22 July 2019

Gilgandra Solar Farm Amendment to Development Application

APPENDIX 1: GENERAL LAYOUT OF DEVELOPMENT

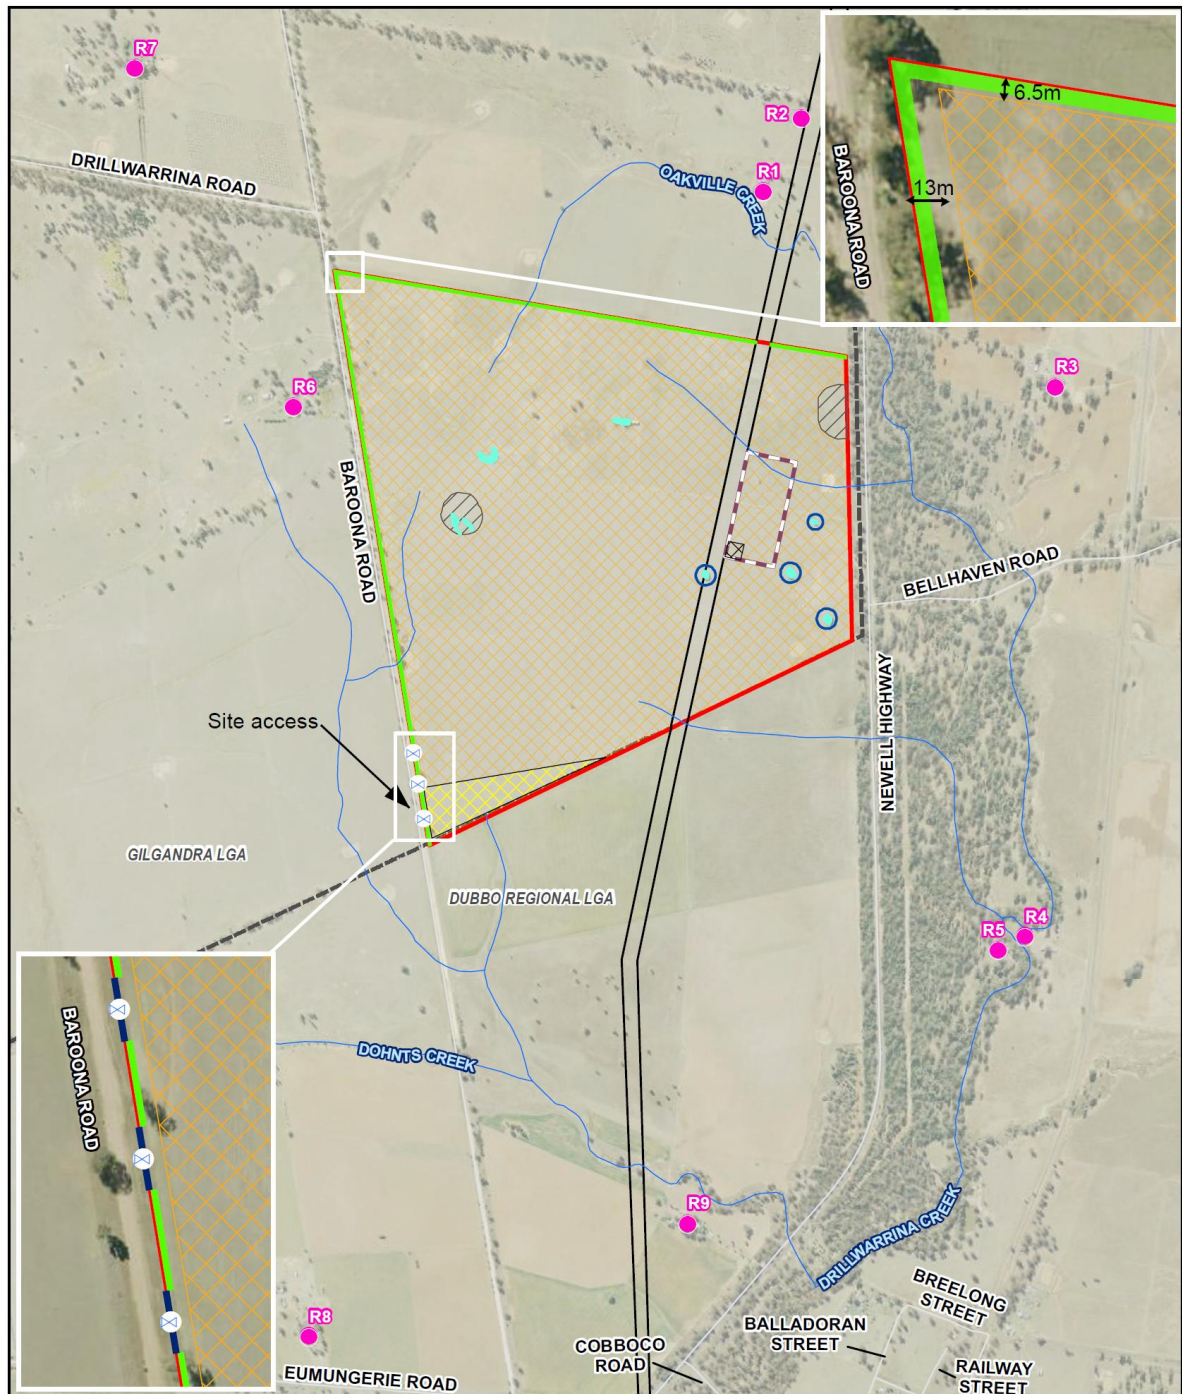
Upon preparation of the general layout of development plan for Appendix 1 of the Development Consent, two areas of vegetation exclusion zone were mistakenly added that are inconsistent with SSD 6785 Appendix 1.

These vegetation exclusion zones are proposed to be removed by this amendment as activities associated with the modification impact or require the vegetation removal.

Attached is the rectified Appendix 1 plan with the two areas of vegetation exclusion zone removed.
